**DELEGATED DECISION FOR APPLICATION FOR CERTIFICATE OF
LAWFUL DEVELOPMENT**

Reference no.: 2026/CL/90668/W

Site: 7, Bedford Close, Lepton, Huddersfield, HD8 0DY

Description: Certificate of lawfulness for two storey rear
extension

Scale: 1:50 & 1:100	Drawing Number 2026/005/03	Rev. February 2026	Date Drawn February 2026	Drawn By Andrew Smith
------------------------	-------------------------------	-----------------------	-----------------------------	--------------------------

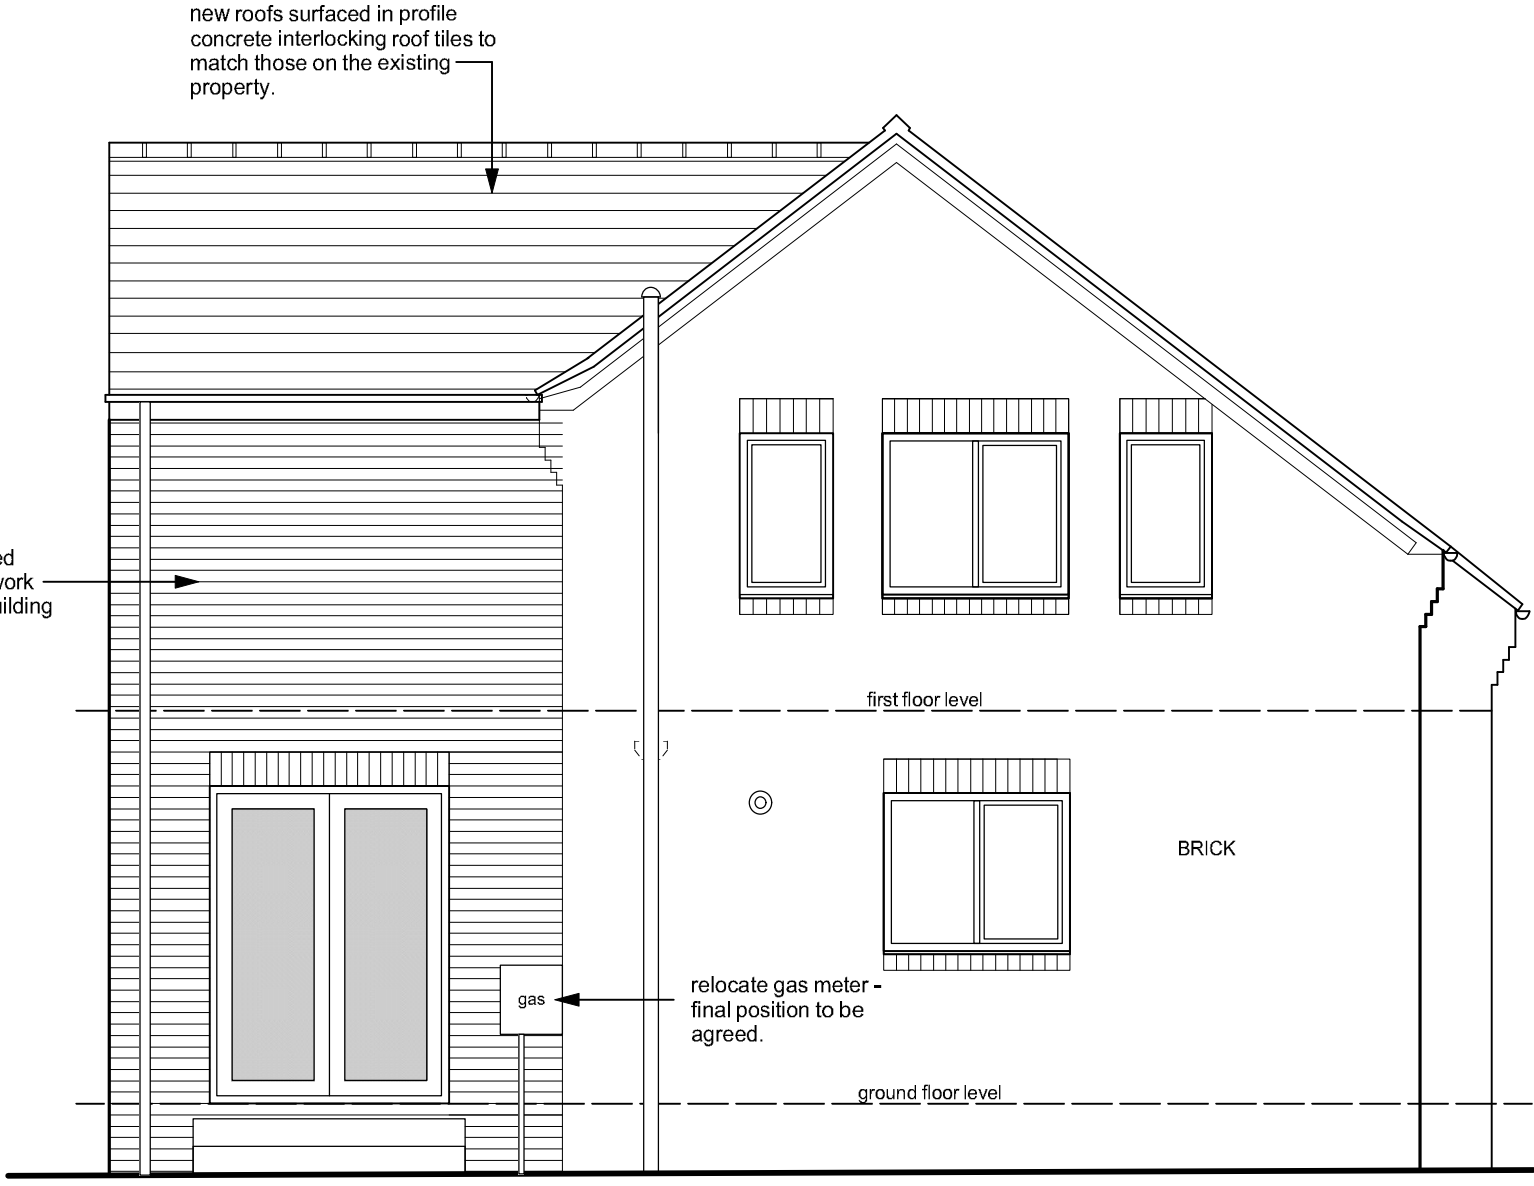
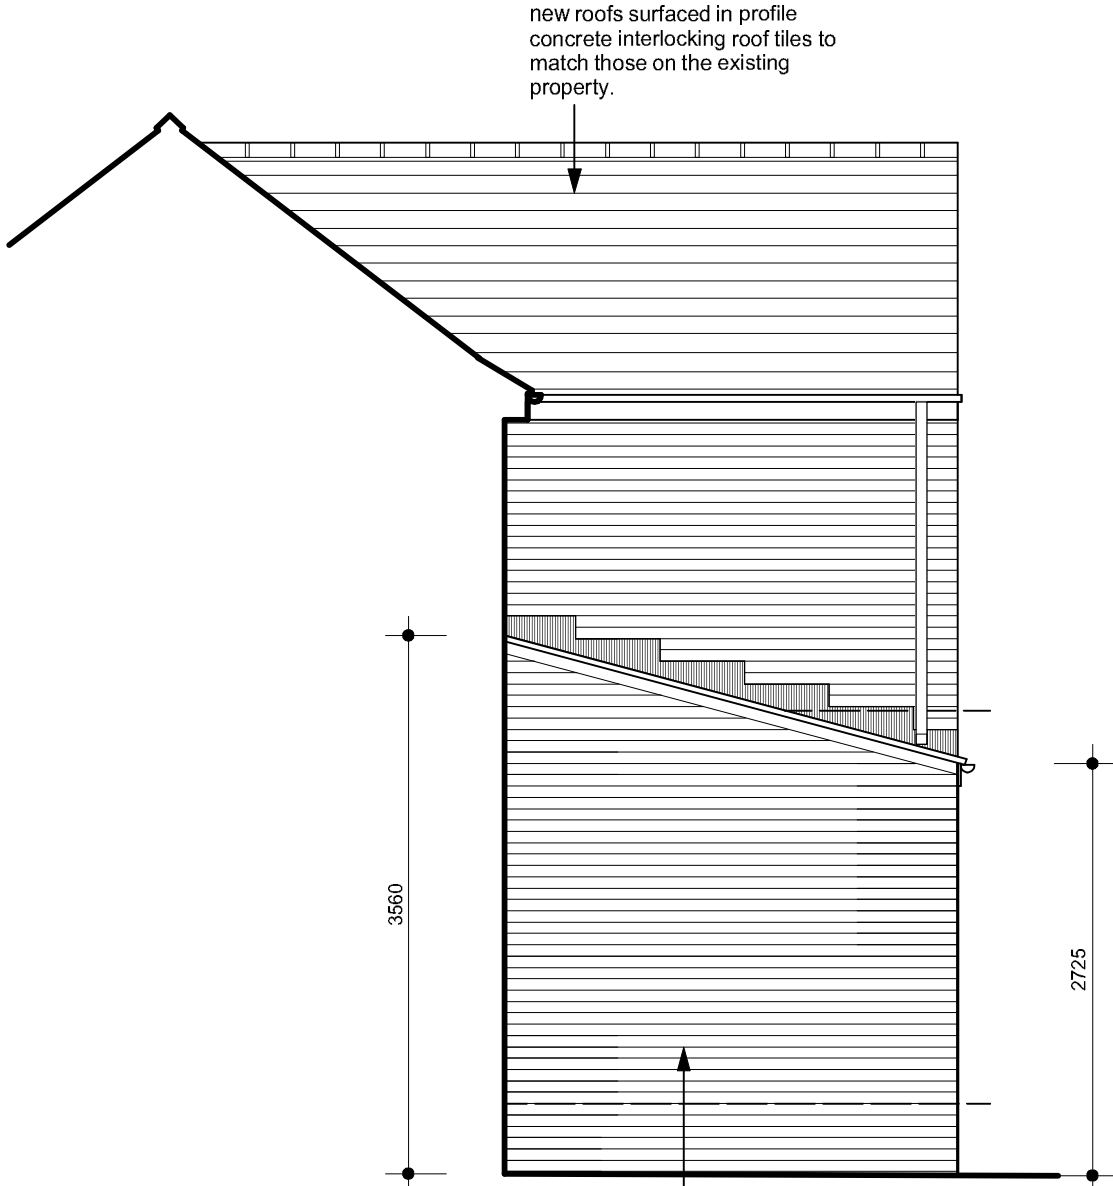
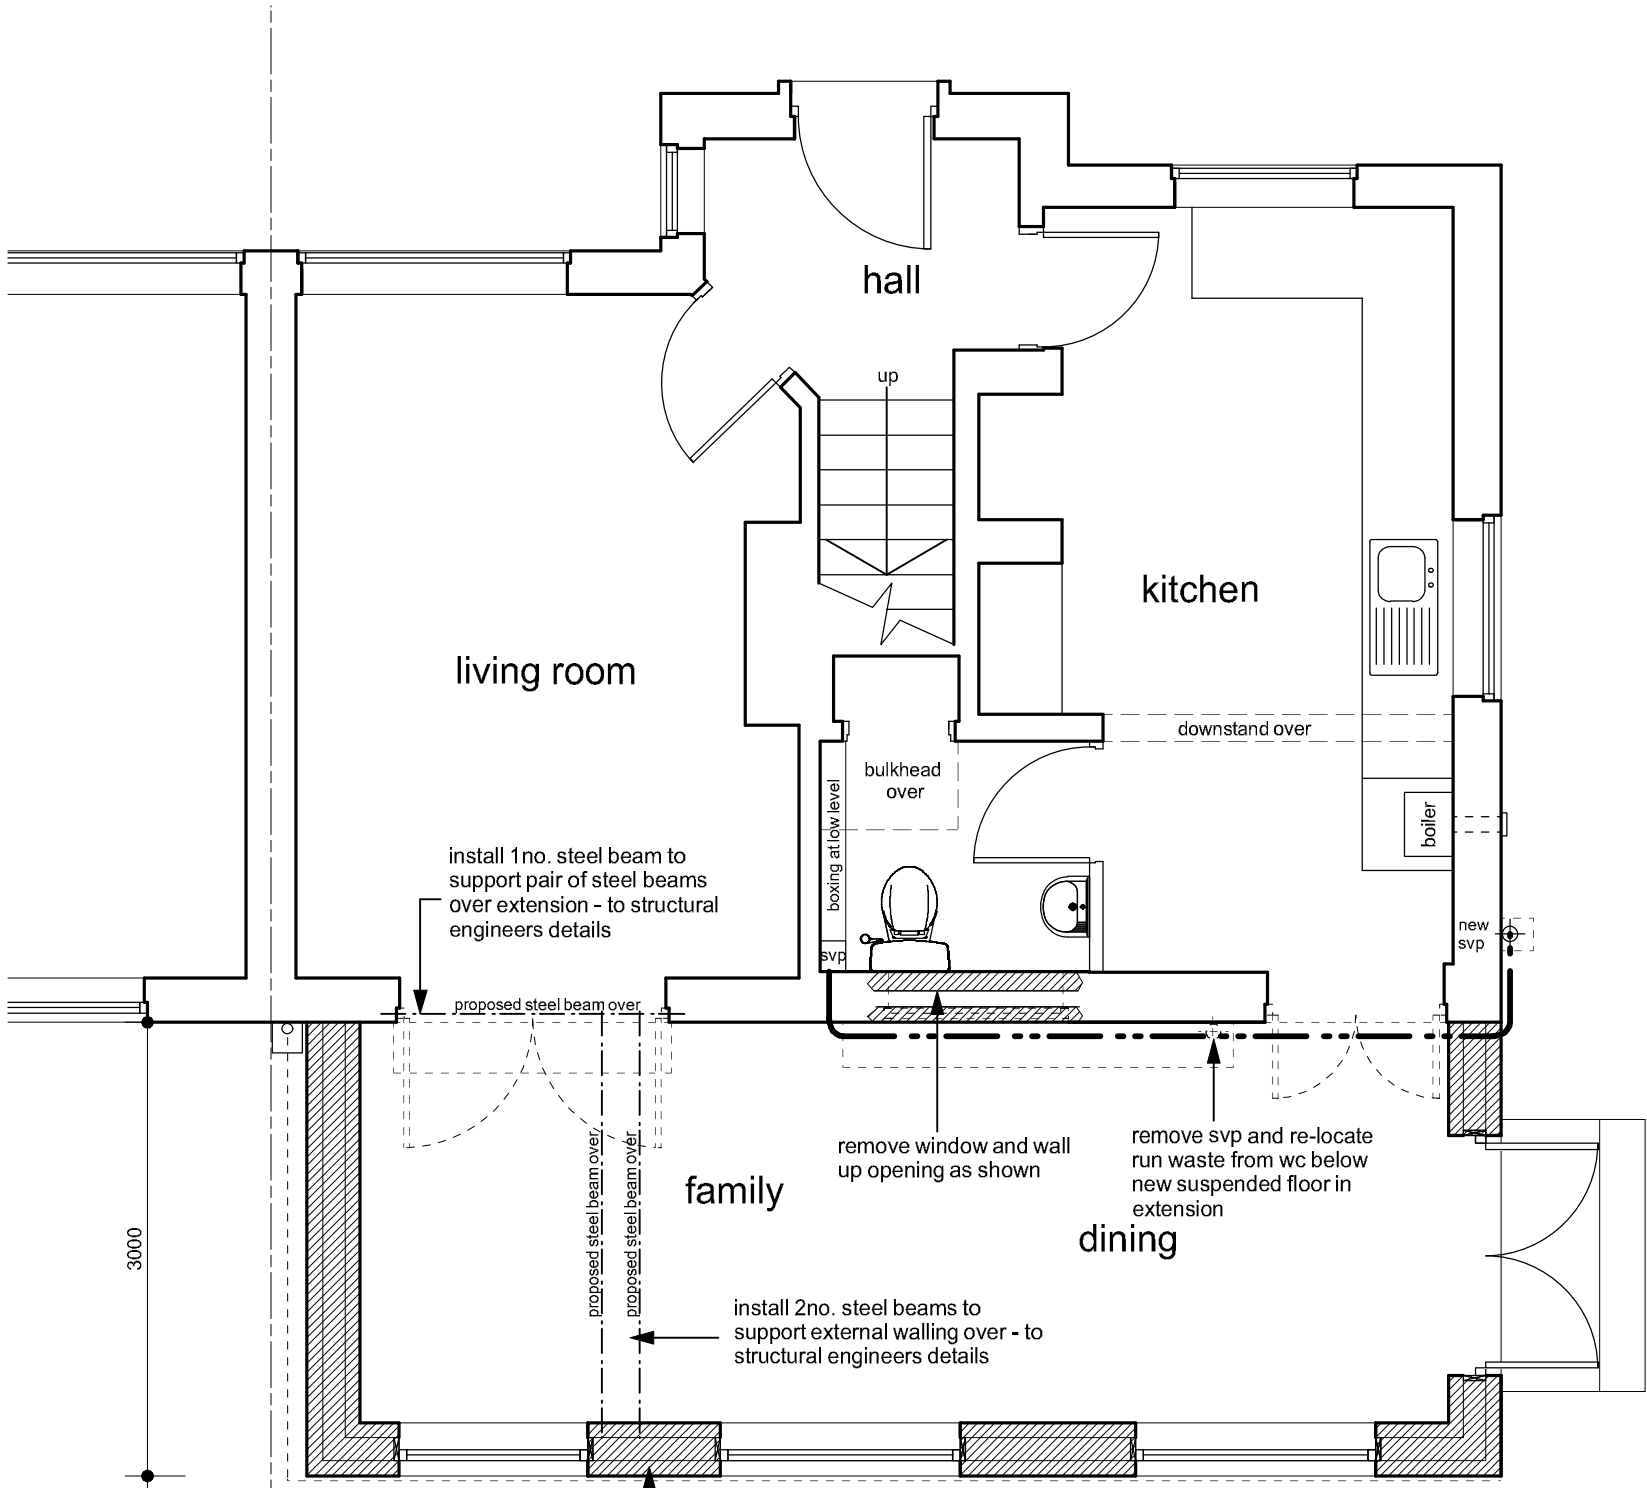
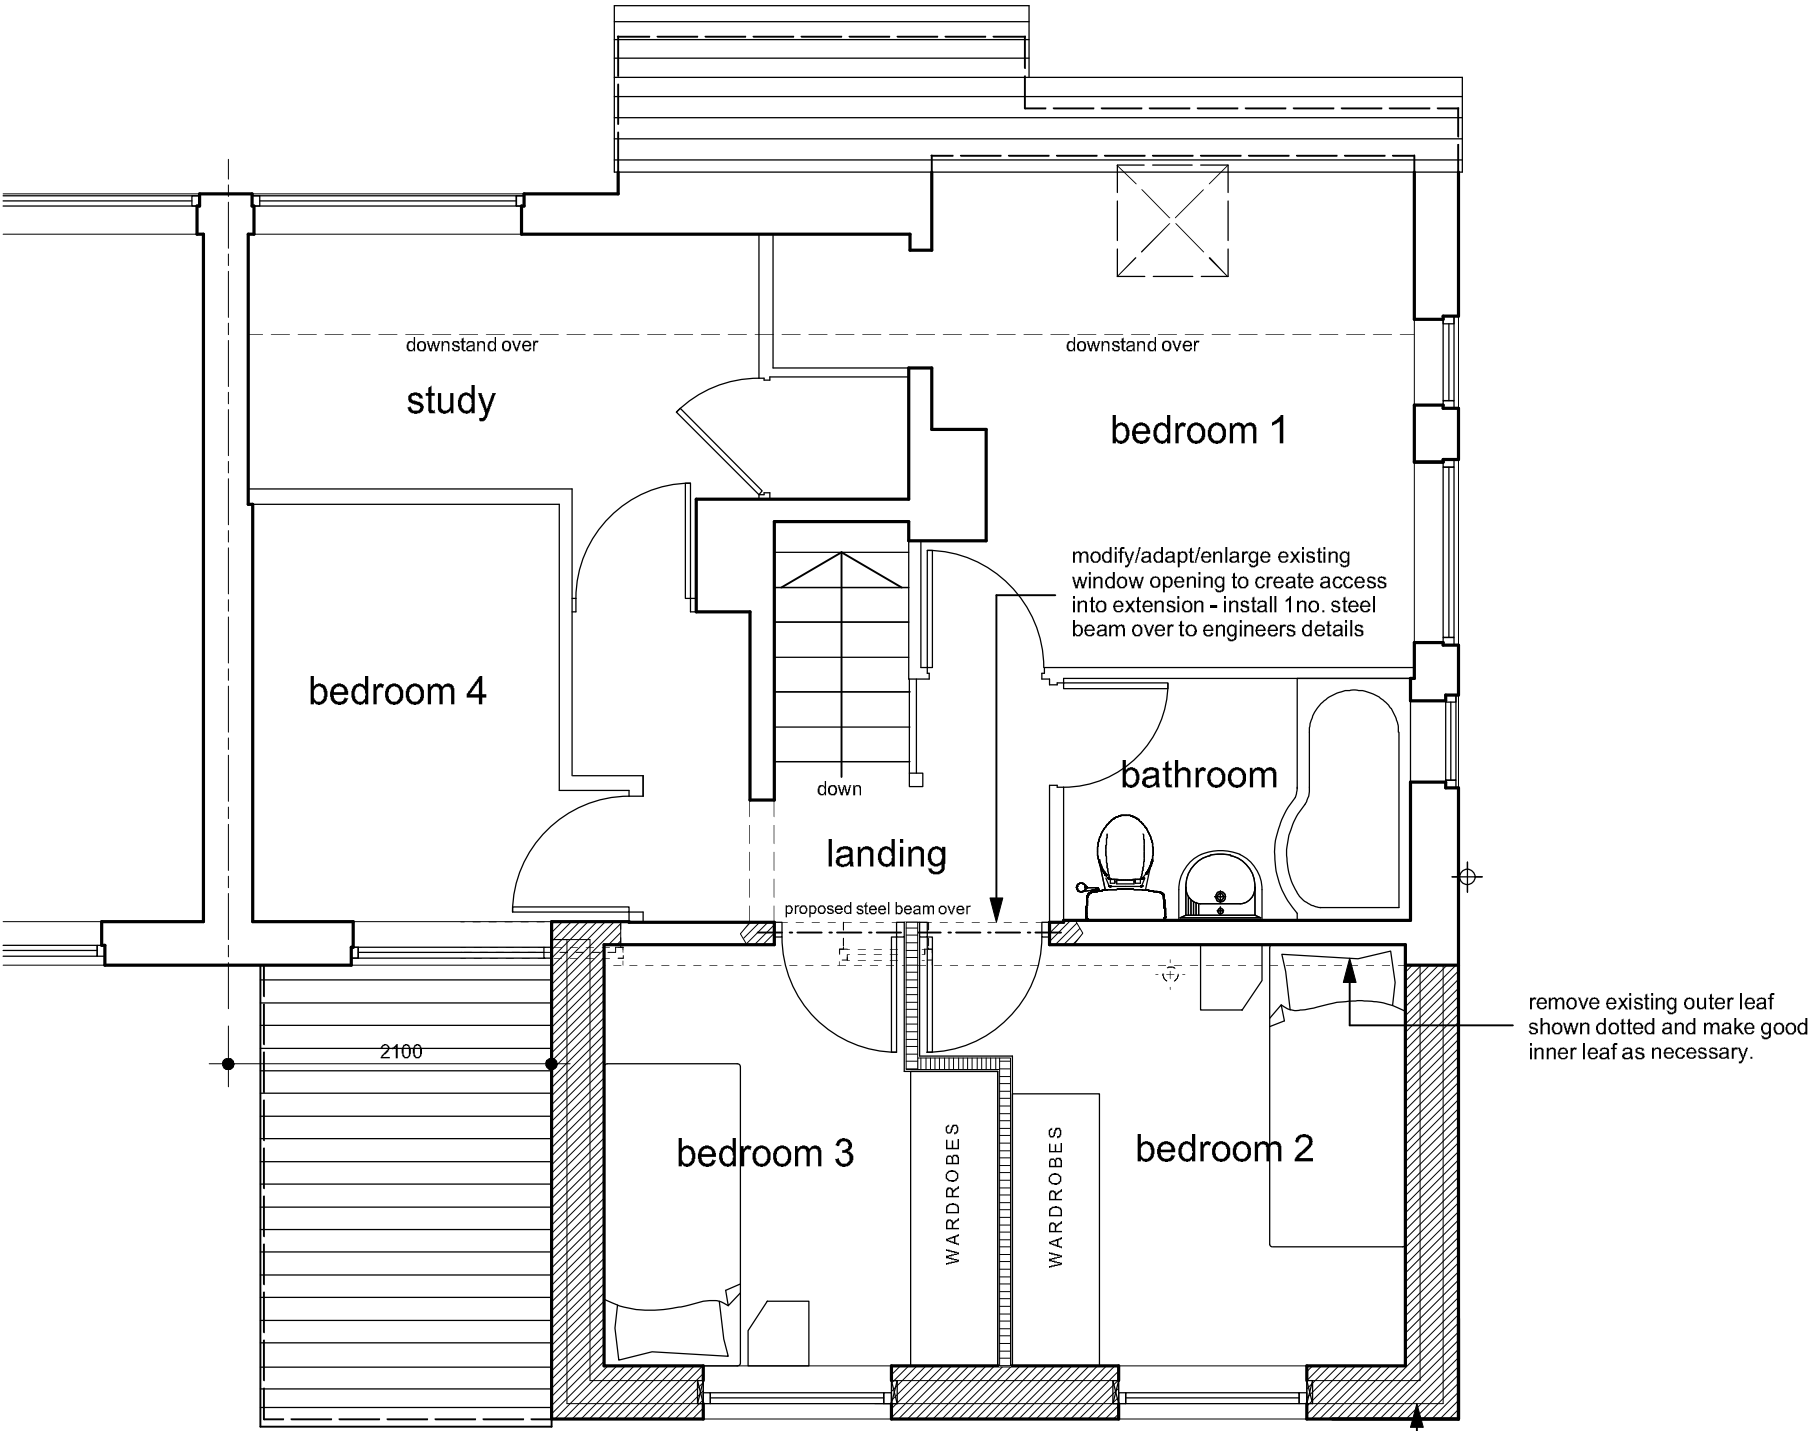
Negotiations have taken place with the Agent as the original scheme also demonstrating a single storey enlargement which would attach to the proposed two storey enlargement. As the proposed works would fall to be considered as a two storey enlargement in totality, inclusion of the single storey element would fail to comply with current legislation. As such, discussions took place with the Agent and the single storey element has been removed from the scheme. Therefore, the plan to be considered is reference 2026/005/03A received on 18th May 2026.

In this case, the application form and submitted details only refer to the construction of a two-storey rear extension. The works demonstrated on the submitted plans (ref: 2026/005/03A) indicate that the roof of the proposed two storey element of the extension would cut into and attach to the existing form. Class A of Part 1 of The Town and Country Planning (General Permitted Development) (England) Order 2015 (as amended) only relates to extensions to dwellinghouses with Class B referring to alterations to the roof. Therefore, the proposal falls to be considered under Schedule 2, Part 1, Class A and Class B of the aforementioned regulations.

In terms of the roof alteration, the plans, when measured, indicate that the volume increase of roof space would be circa 25 cubic metres.

Comment: *The proposal would result in the alteration of part of the roof of the dwellinghouse. Therefore, the enlargement would fall to be compliant with Schedule 2, Part 1, Class B.*

Comment: *The cubic content of the resulting roof space would not exceed 50 cubic metres. The proposed additional volume is within this limit.*
